**OXFORDSHIRE COUNTY COUNCIL’S RESPONSE TO CONSULTATION
ON THE FOLLOWING DEVELOPMENT PROPOSAL**

Application no: 23/00173/OUT

Proposal: Outline planning application for up to 147 homes, public open space, flexible recreational playing field area and sports pitches with associated car parking, alongside landscaping, ecological enhancements, SuDs, green/blue and hard infrastructure, with vehicular and pedestrian/cycle accesses, and all associated works (all matters reserved except for means of access)

Location: Land South Of, Green Lane, Chesterton

Existing Ditch Network

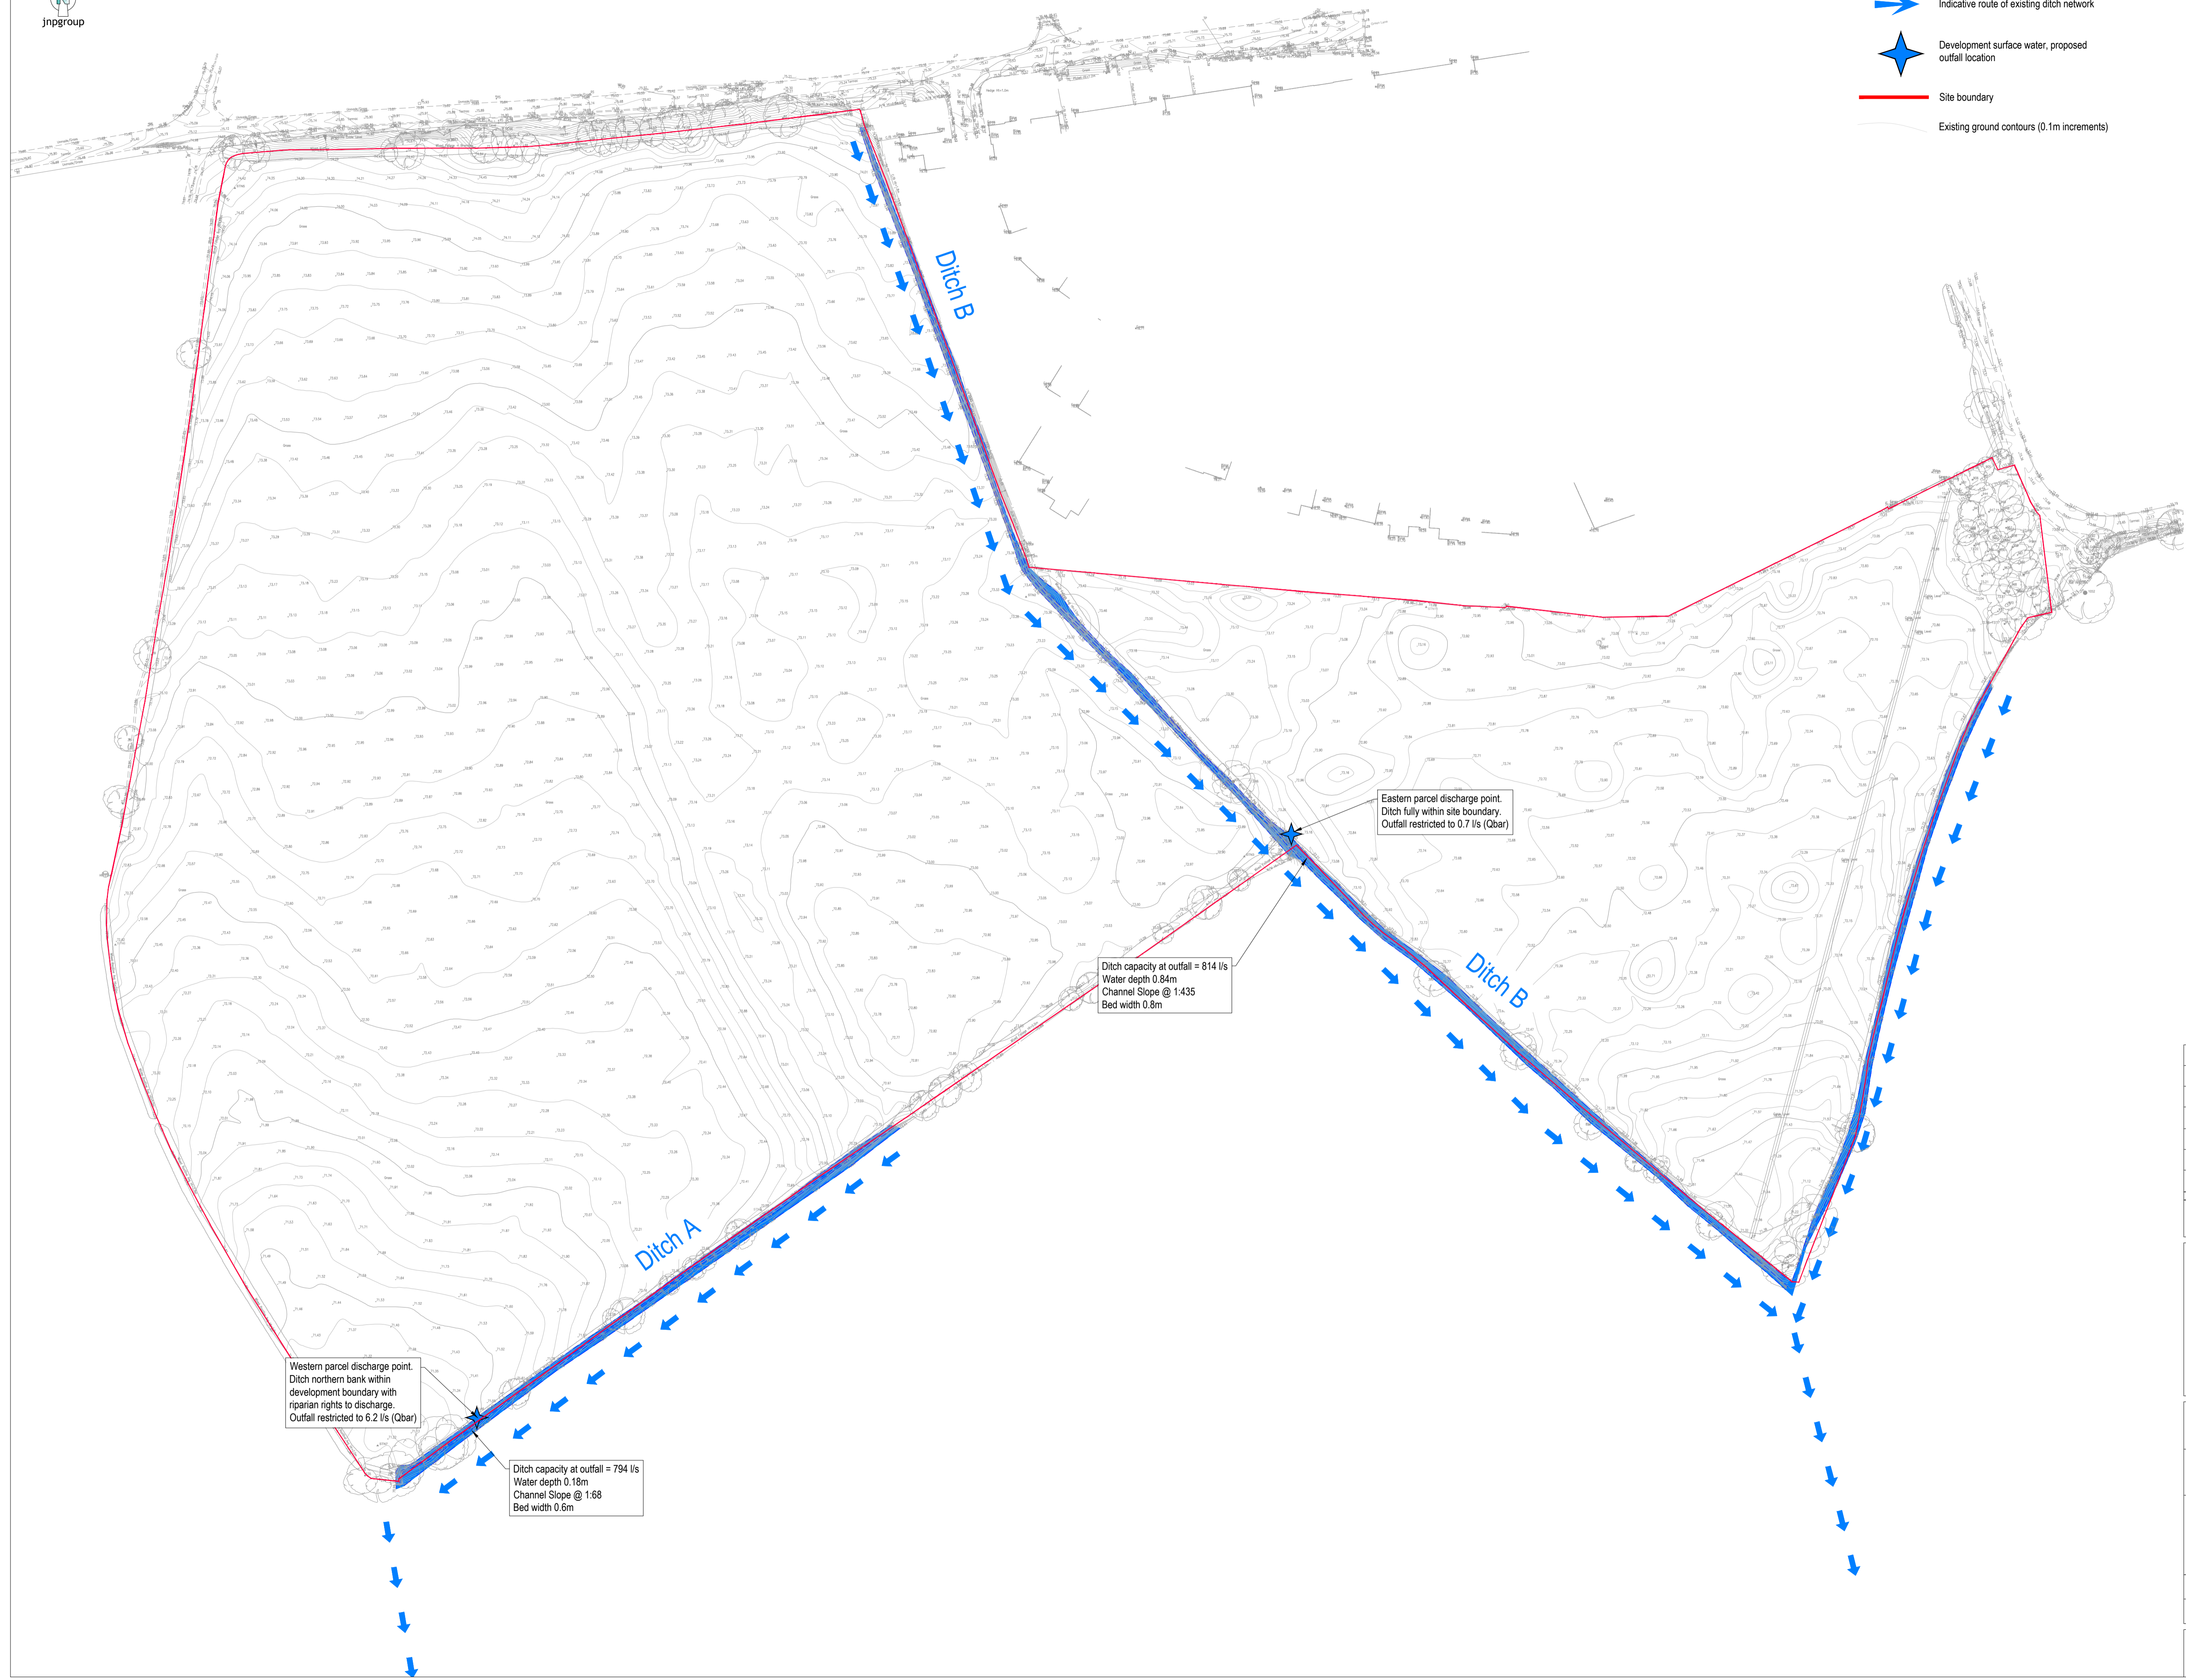
Provide details of the existing ditch, provide ownership details and consent to discharge surface water. Ensure the existing ditch has enough capacity to take the proposed loads from the development.

APPENDIX B. SITE ACCESS VERTICAL ALIGNMENT

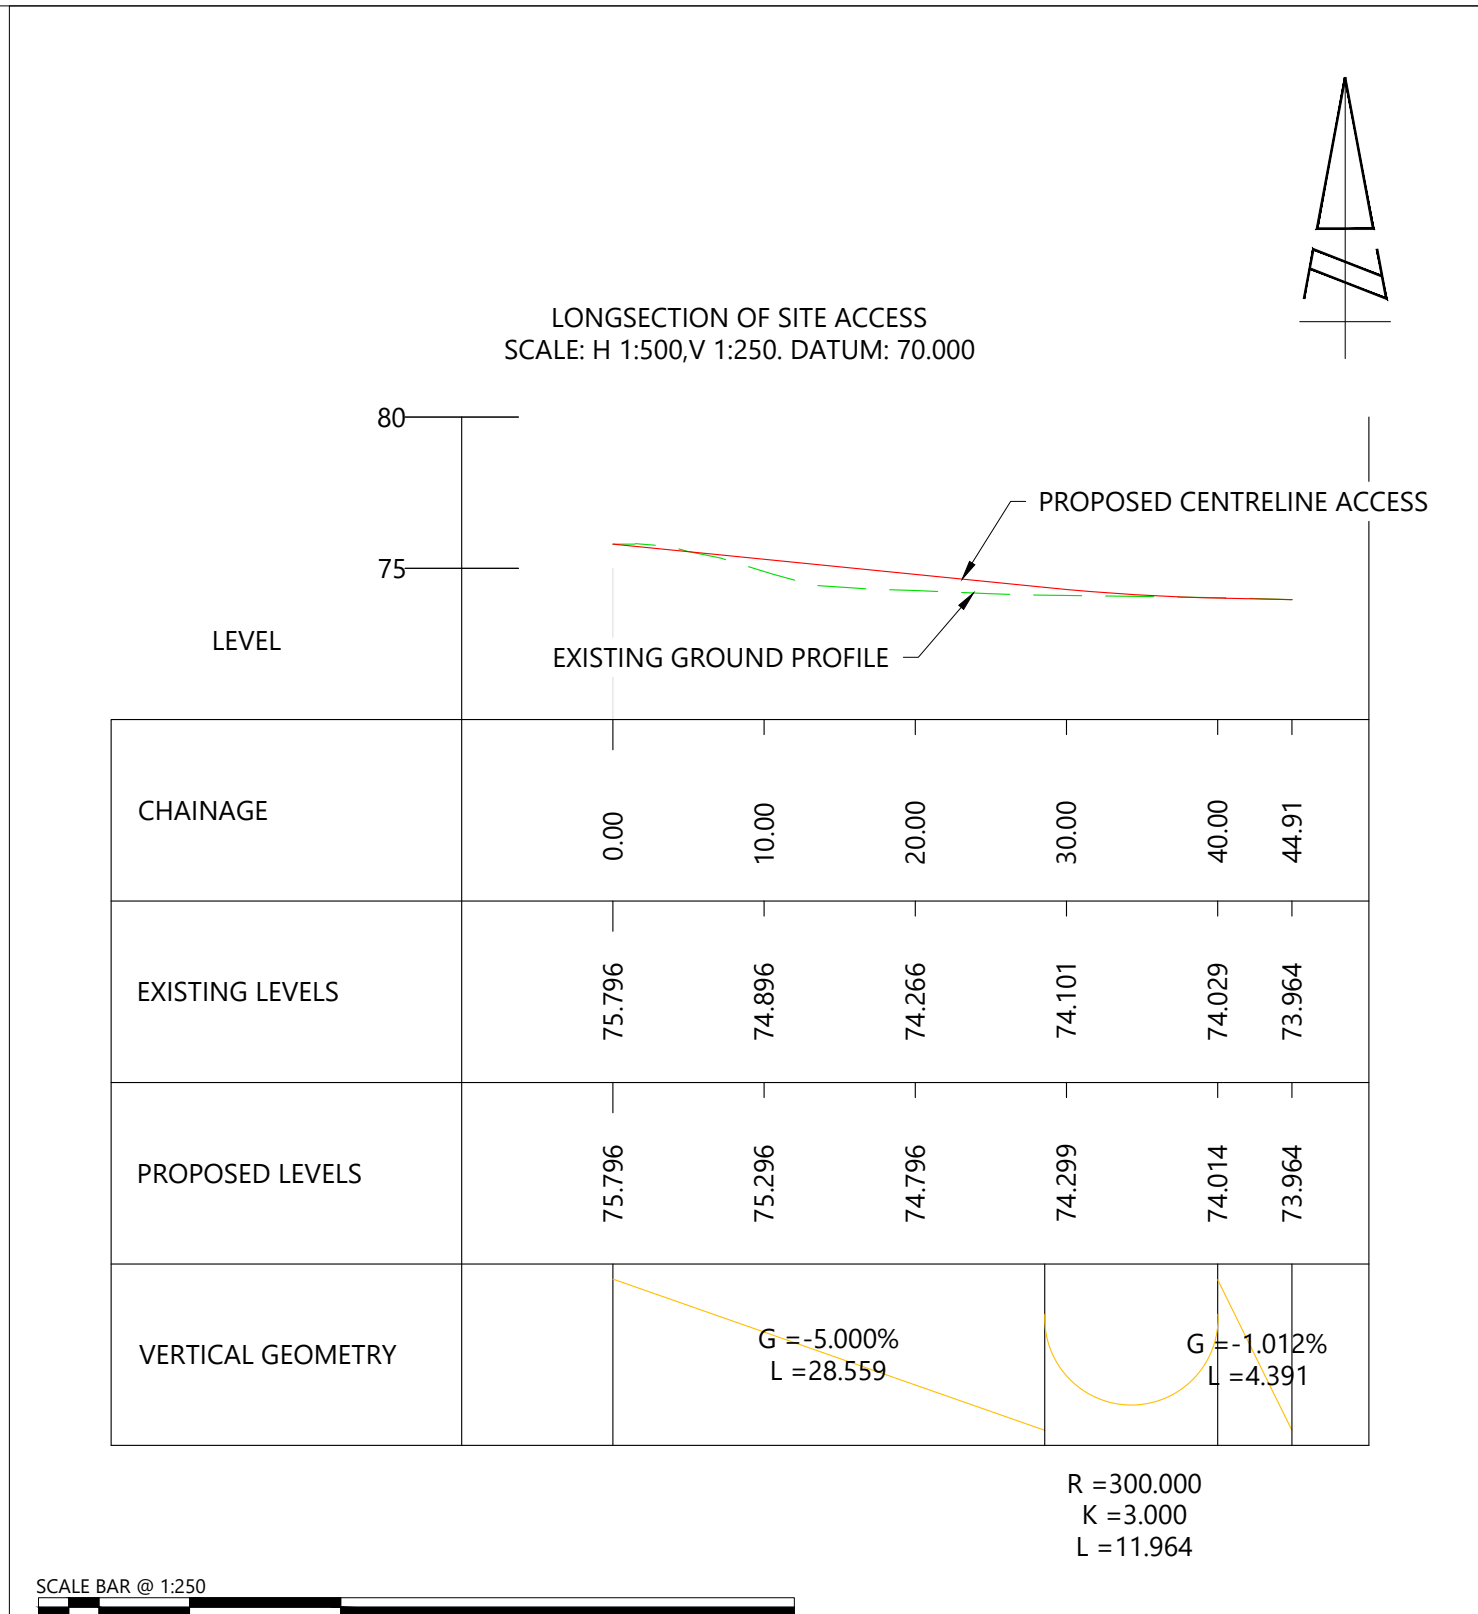
A long section has not been provided and will be required to ensure compliance with the Equalities Act 2010. This must include details of the vertical alignment to determine appropriate carriageway and footway gradients. They will need to be DDA compliant i.e. maximum 1:21 or 5%. This will be required at the Section 278 stage.

DRAWN:	JD	CHECKED:	IN	APPROVED:	TW
PROJECT No:	ITB14377	SCALE @ A3:	1:1000 / 1:500	DATE:	19.08.20
DRAWING No:	ITB14377-GA-001	REV:	F

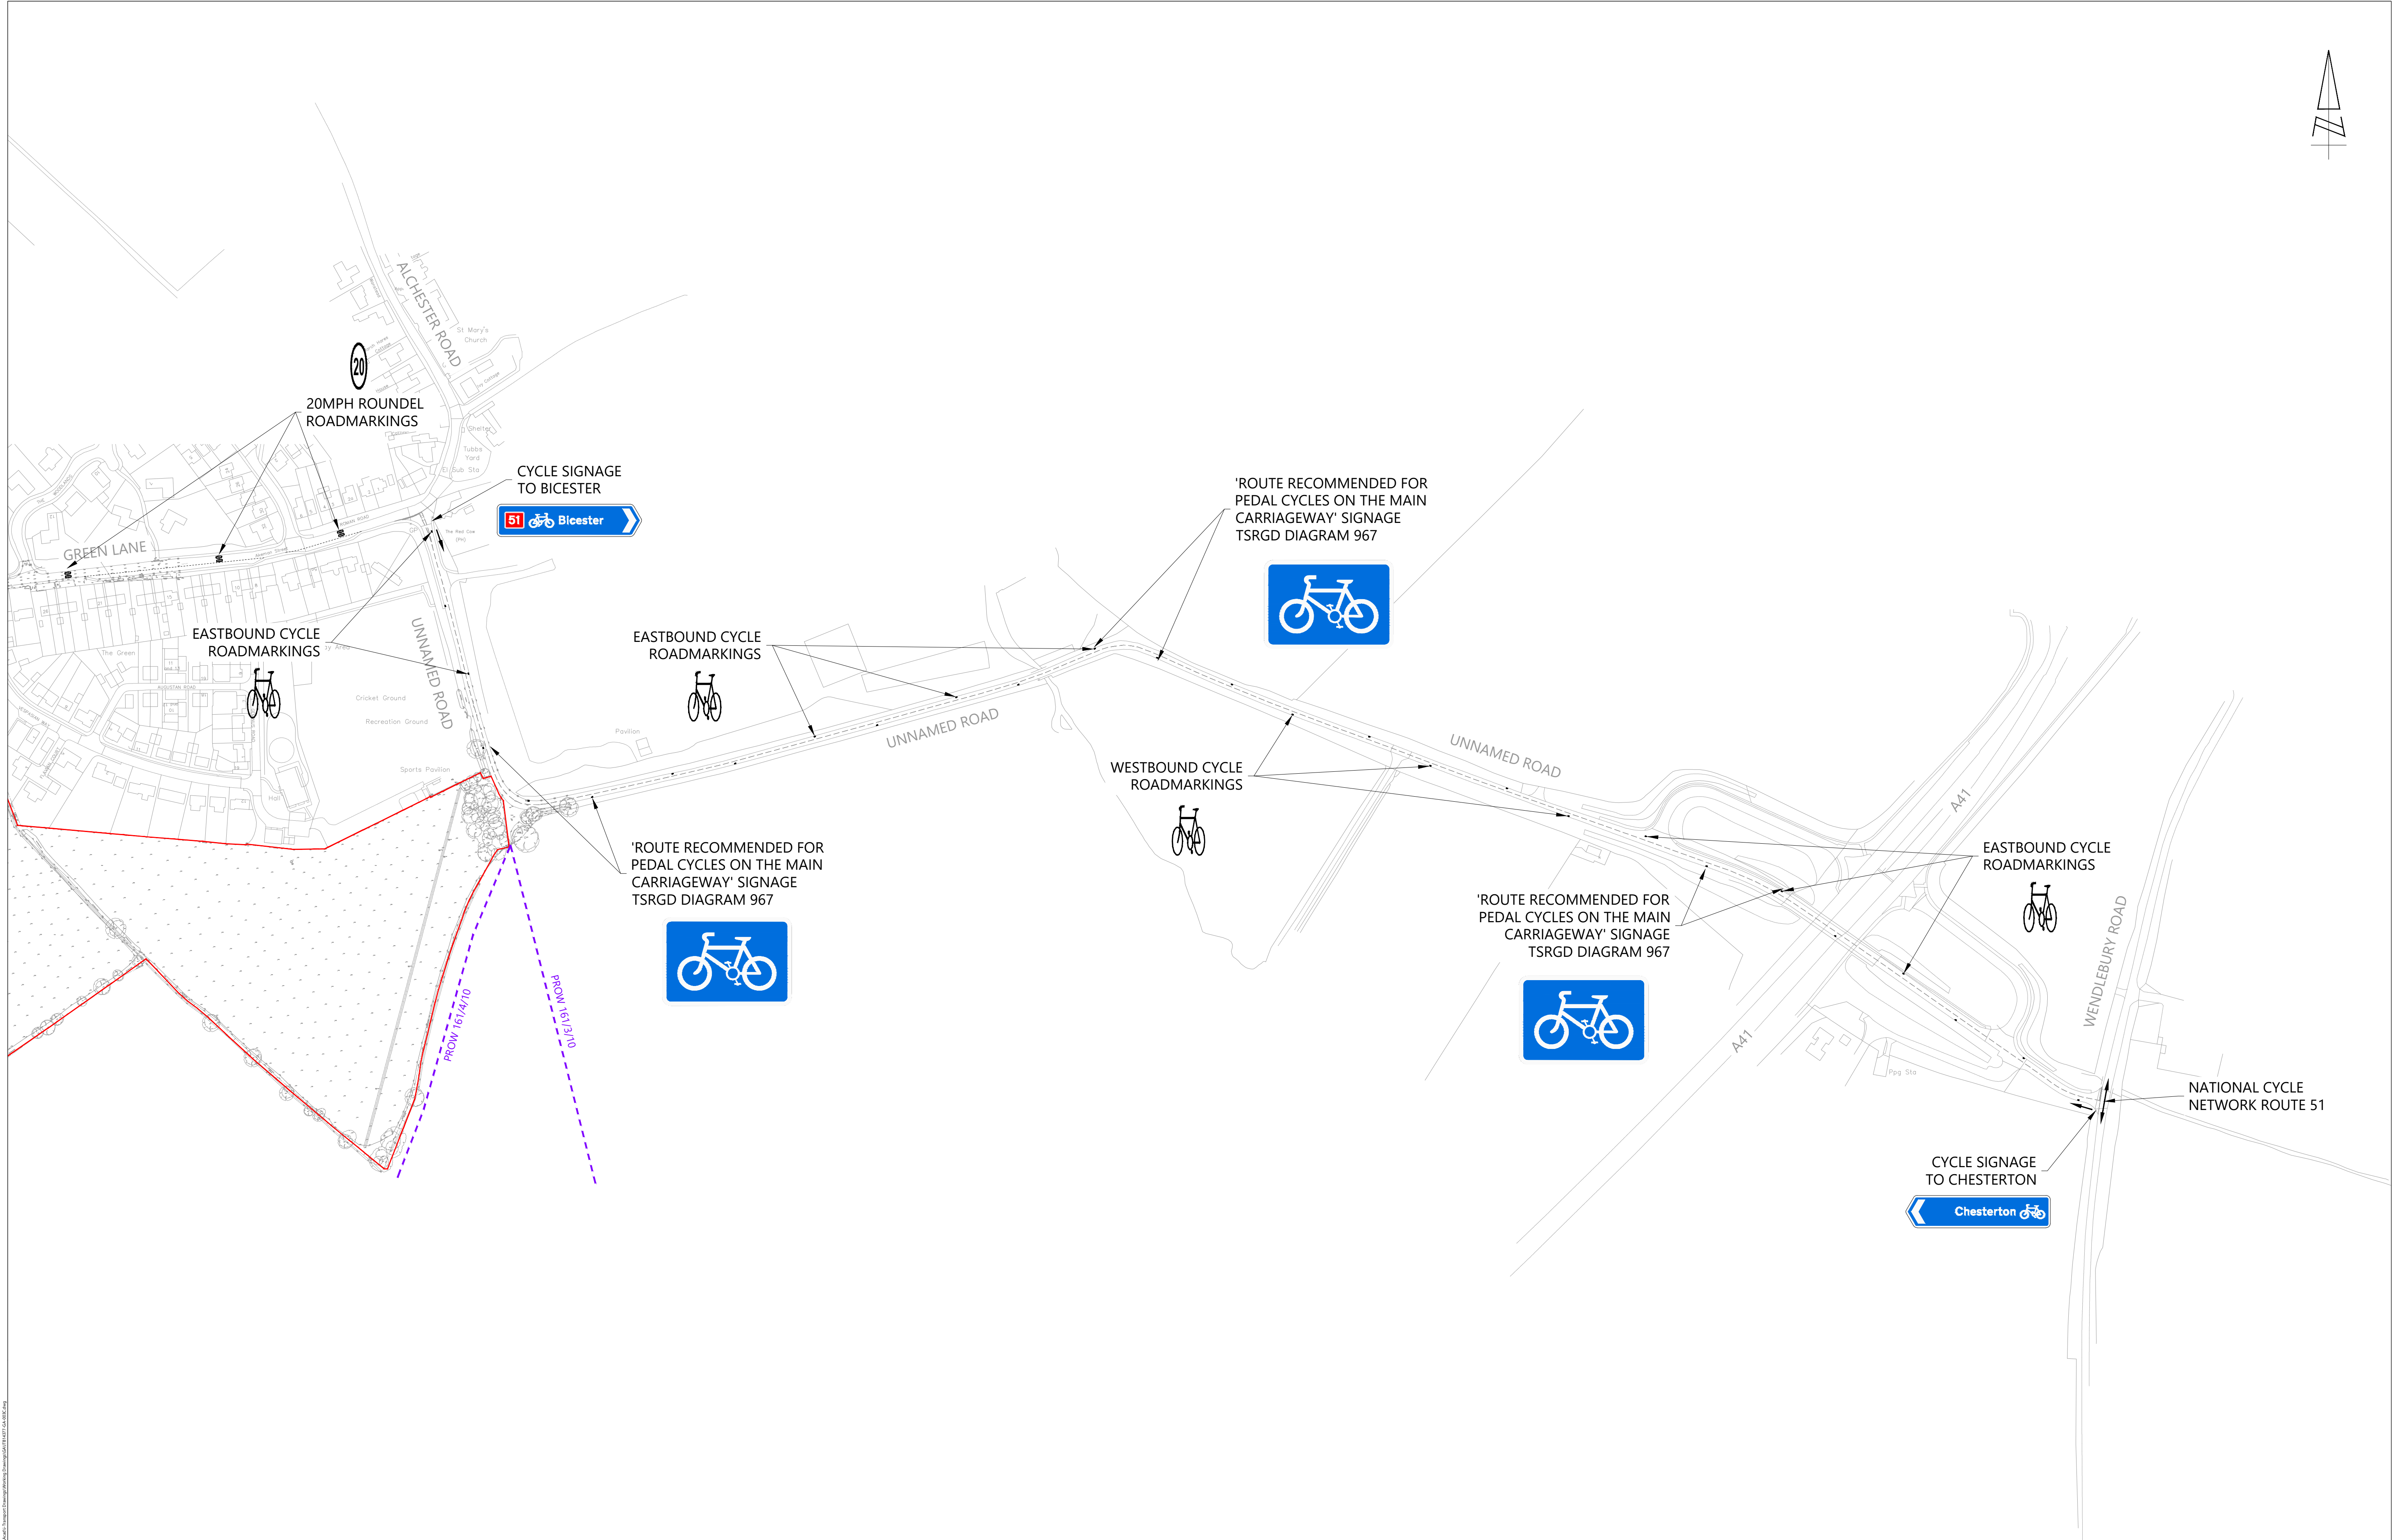
- Section 4.3 presents site access arrangements. These are considered acceptable and can be the subject of a Section 278 agreement. However, a long section has not been provided and this is considered necessary. Further details are given below under the **Road Agreements** heading.

Some areas of refuse vehicle tracking indicates the vehicle overhanging the footway. This is a concern for conflict. The lane overhang at the entrance should be reduced as it appears to track entirely over opposite lane.
